Subject: RE: Discharge of Condition 5 BE/18/17/PL - New Barn Lane, North Bersted

Condition 5 (surface water drainage)

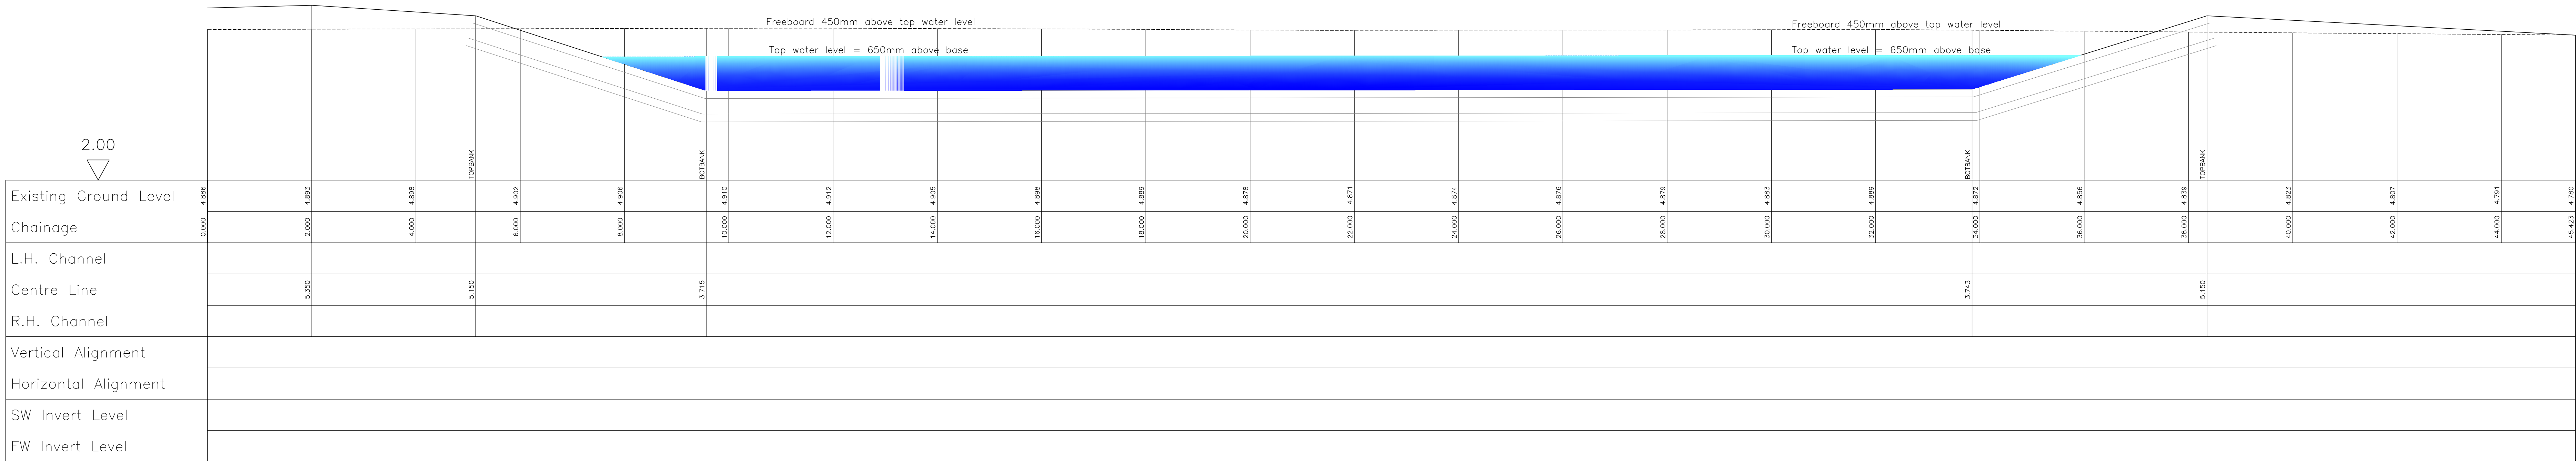
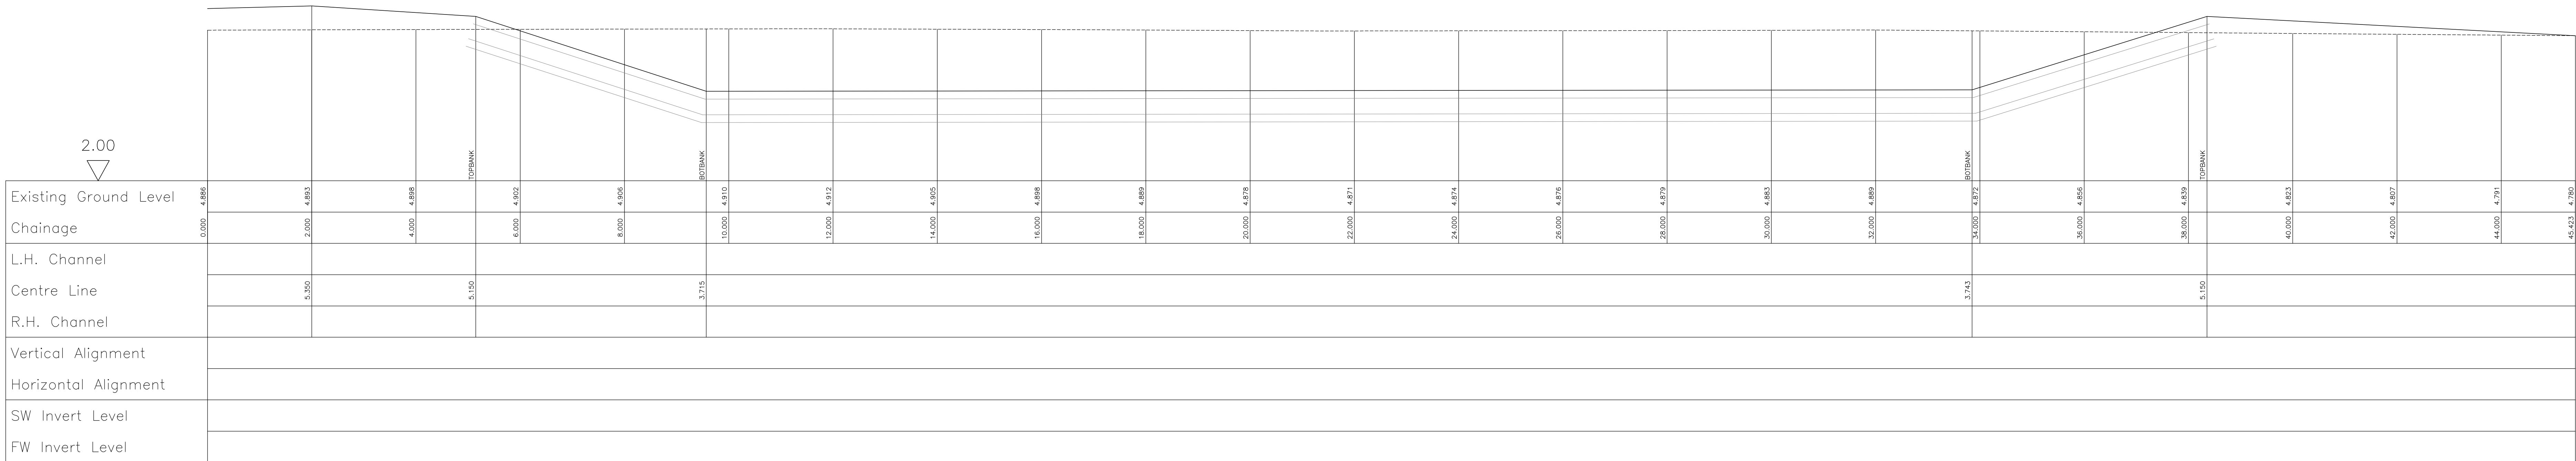
4. The cross section detail of the pond outfall needs to show the headwall will be graded into the bank. Please update the cross section to ensure turf layer etc. follows the dashed line and meets the top of the headwall. One additional line needs to be added to the section. An amended cross section will be within the dropbox link

4. The cross section detail of the pond outfall needs to show the headwall will be graded into the bank. Please update the cross section to ensure turf layer etc. follows the dashed line and meets the top of the headwall.
5. Please supply uplift calculations for the attenuation tanks with submission.
6. Please can you provide an update regarding the ordinary watercourse land drainage consent. Without this you cannot implement the scheme and therefore will not be able to comply with the condition.

I note that the revised pond detail means that you are now displacing extra groundwater. It would be good to get some revised calculations submitted just to show that you have considered this and that design is okay.

c).....As I stated back on the 6th December it is not acceptable to have the inlet into the pond below the turf layer. Please revise this.

e) Layouts need to be updated at the pond to show formation and finish level. Currently the pond is undulating significantly, I would like to see this revised to be smoother.

MJA Response – Noted. Swale sections revised, concrete ditched channel added to details; Please revise the detail to show that the ditched channel will be embedded in concrete.

MJA Response – Detail revised as instructed, refer to drawing LWS232-1011 revision K. Okay.

MJA Response—Noted, Pond and sections revised. Okay.

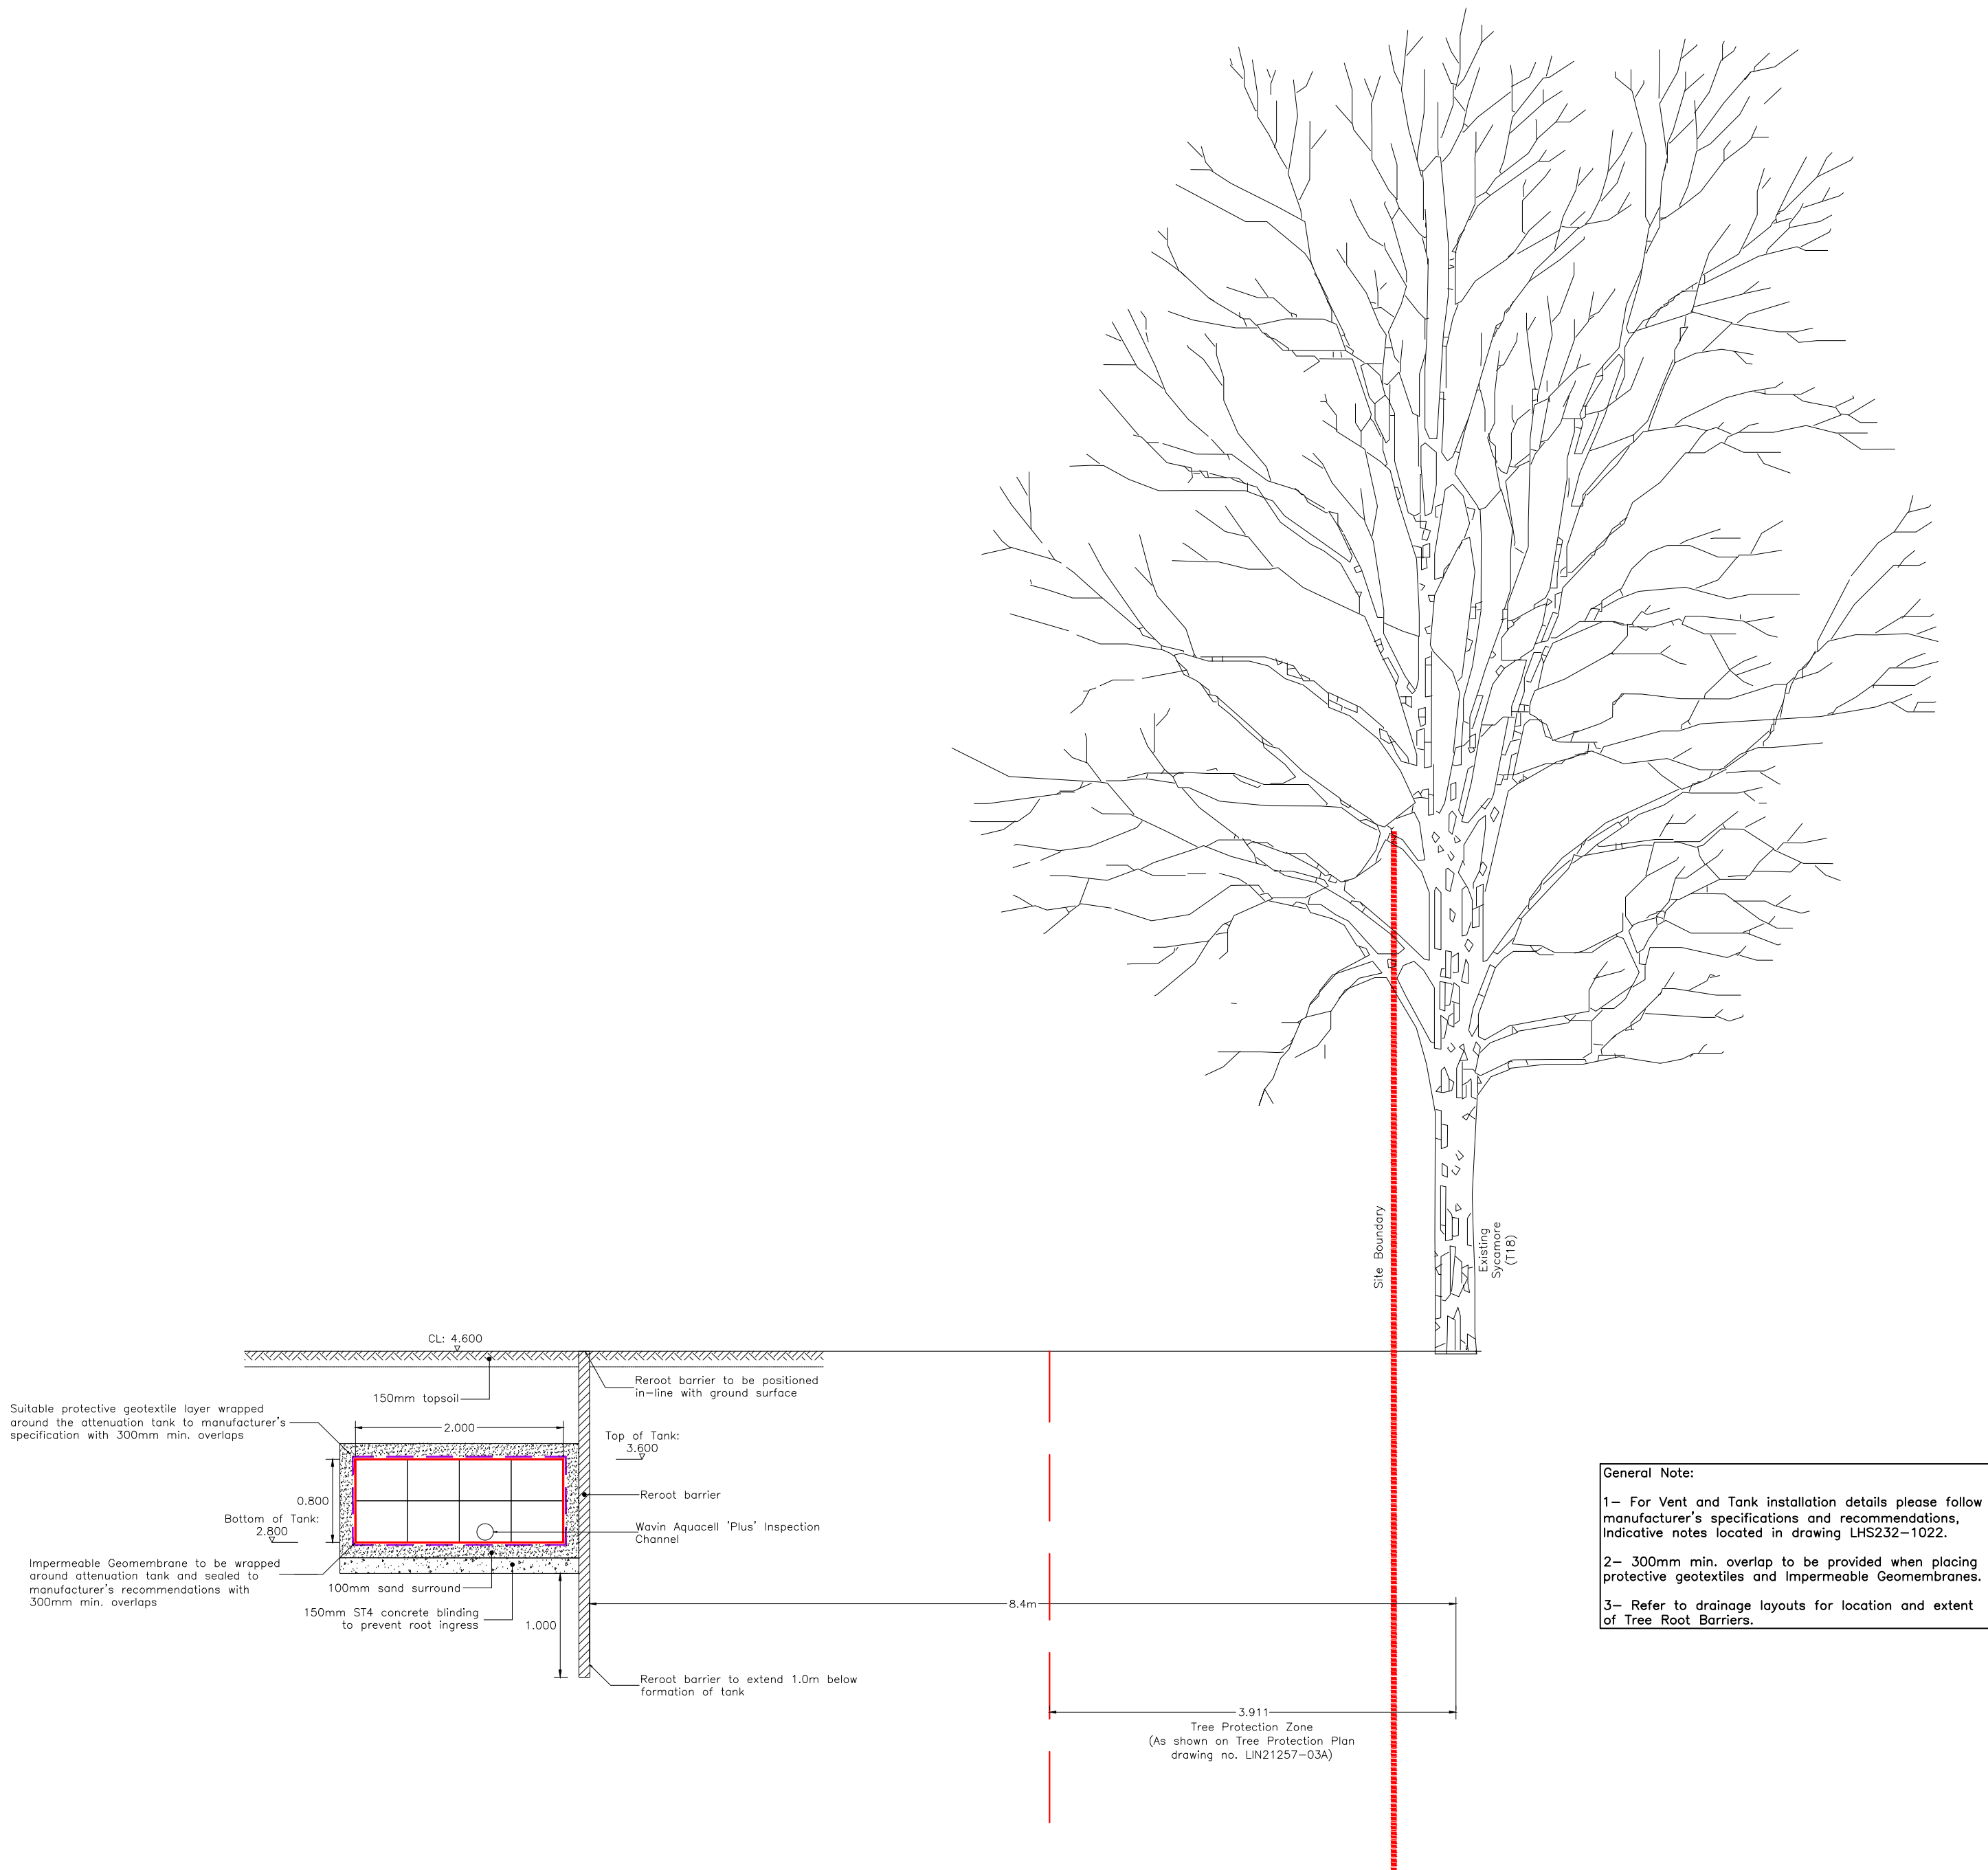
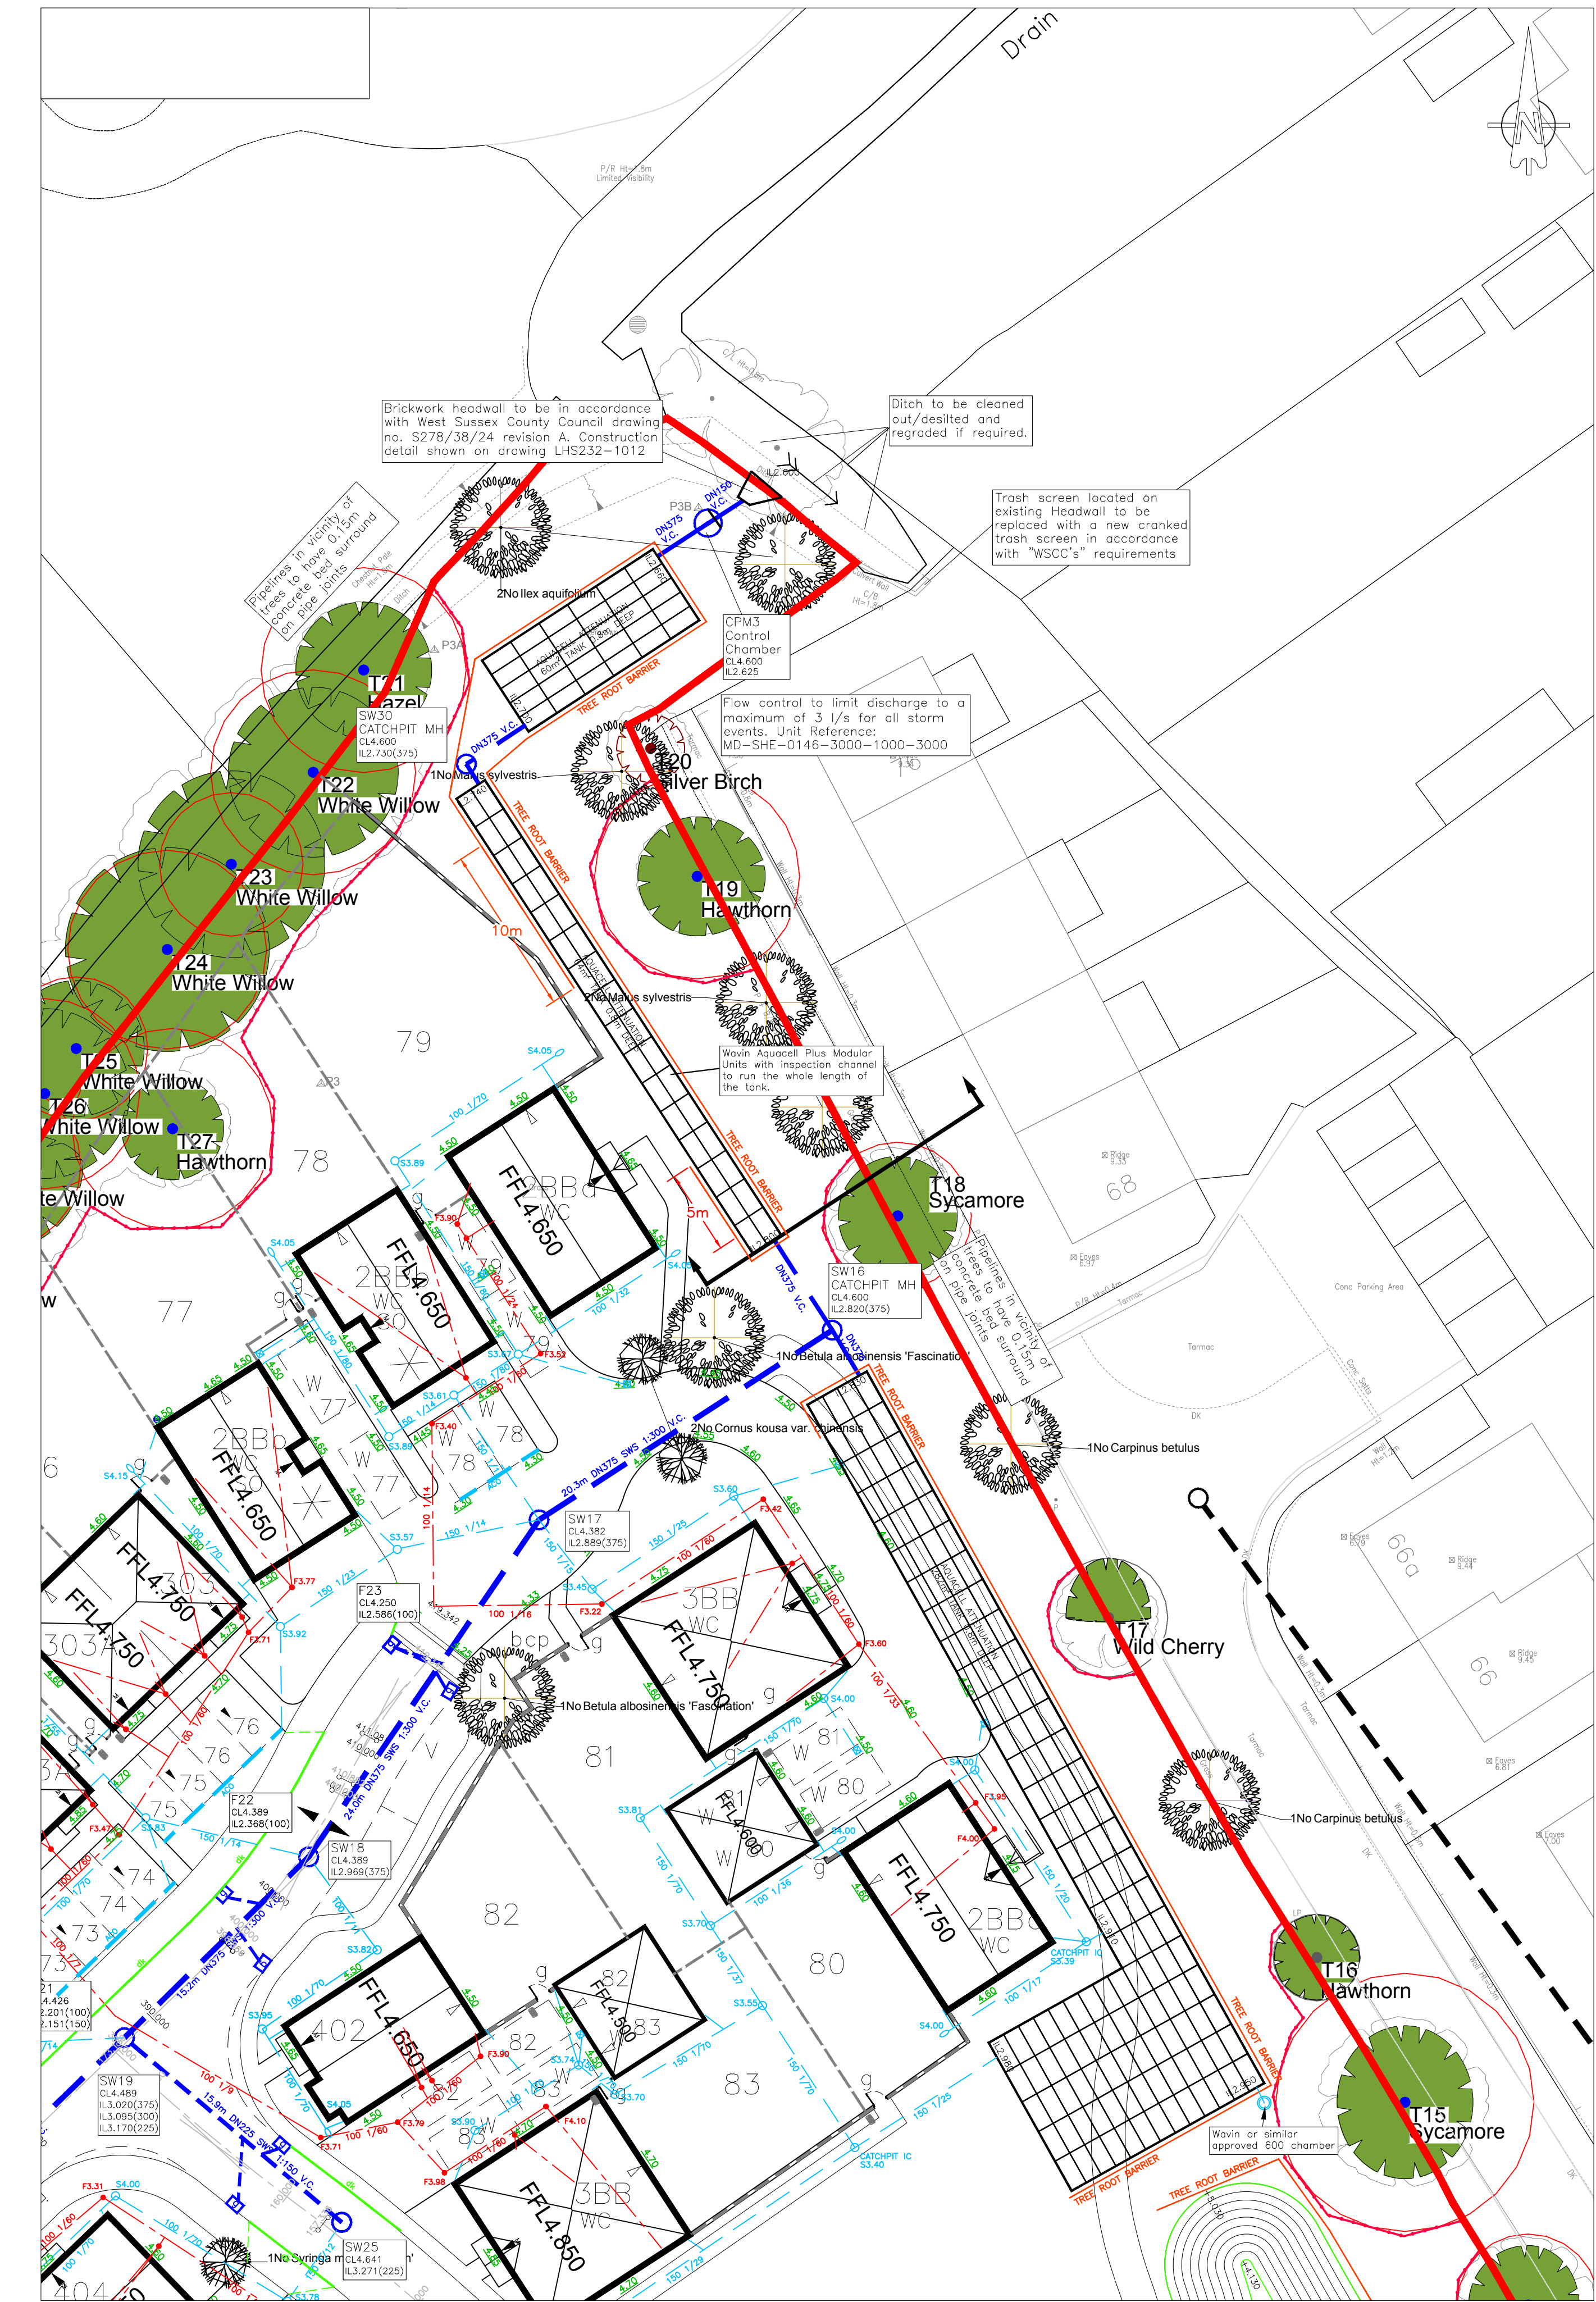
1. The root protection barrier will need to extend to ground surface.

2. 75mm of binding concrete is insufficient. Please provide 150mm of ST4 concrete.

MJA Response—Noted, root protection barrier extended to ground surface. Okay.

MJA Response—Noted, detail revised as instructed. Okay.
